DRB Project Number: PR-2024-010189 Hearing Date: 03-26-2025
TRACT N-1, CORRECTION
PLAT OF TRS N-1 & N-2
WATERSHED SUBD
located at
9601 TIERRA PINTADA BLVD
between TIERRA PINTADA BLVD
NW and ARROYO VISTA BLVD
NW

Project No: PR-2024-010189 Date: 3/26/2025 Agenda Item: #2 Zone Atlas Page: (H-8, J-7, J-8)

Request: Subdivide Tract N-1 into two tracts

SUBJECT: Bulk Plat

MIREHAVEN PKWY

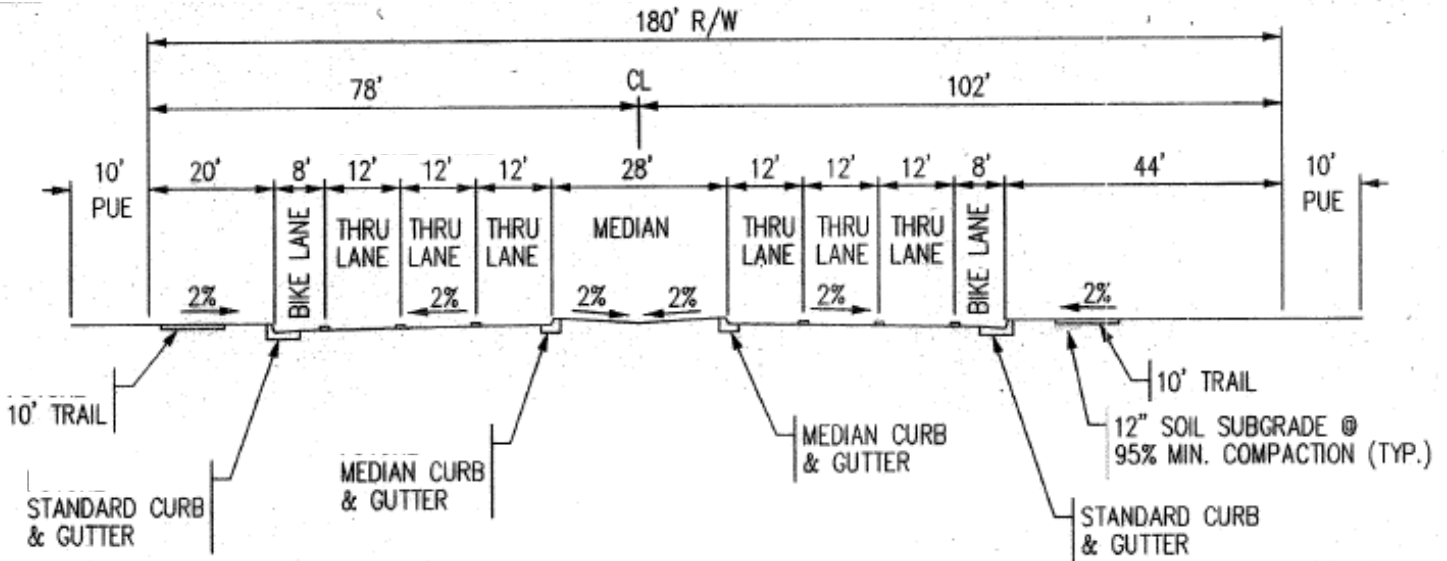
1. The cross sections provided show adequate sidewalk or trails for all roadways, though the landscape buffer for Mirehaven appears to be only 2' wide. Transportation defers to Parks and Planning if this is acceptable. No objections.
